KITTITAS COUNTY DEPARTMENT OF PUBLIC WORKS

December 29, 2022

RE: Illegal access point onto Rein Road
Parcel 951598

SITE PLAN
WALTER DAVENPORT
(17-19-08055-0002)
SCALE: 1" = 120'

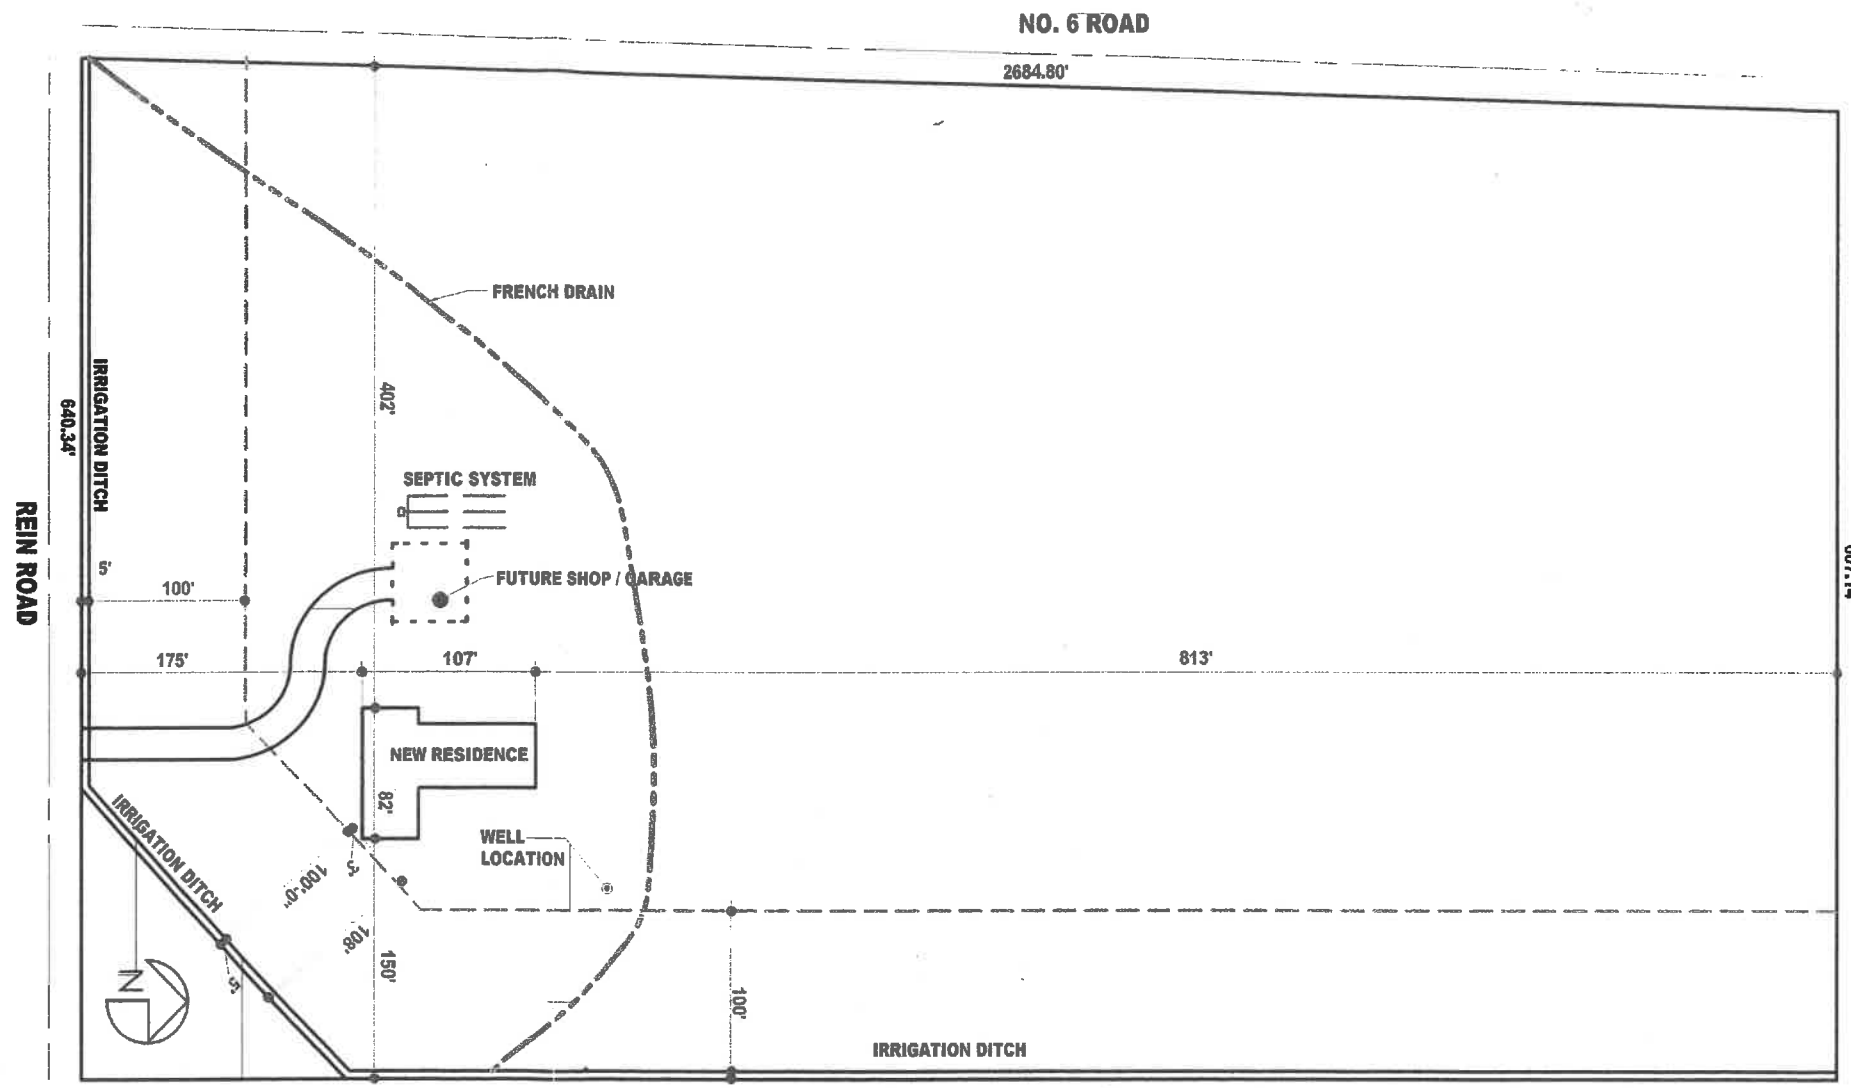
Kittitas County Public Works has located an illegal unpermitted second approach onto Rein Road approximately 150 feet east of your permitted access onto parcel 951598, 141 Rein Road.

Kittitas County Code 12.05.030 states: No more than one access shall be granted to an individual parcel or to continuous parcels under the same ownership unless it can be shown that:

1. Additional access would be beneficial to the public traveling the public road, or
2. Allowing one access would conflict with local safety regulations and the additional access would not be detrimental to the public health, safety, and welfare.

Removal of the illegal approach or an application for a road standards variance needs to be completed by January 20, 2023. If you choose not to apply for a variance to the road standards and do not remove the illegal approach by this date, Public Works will remove the access and bill the property owner for the cost of removal.
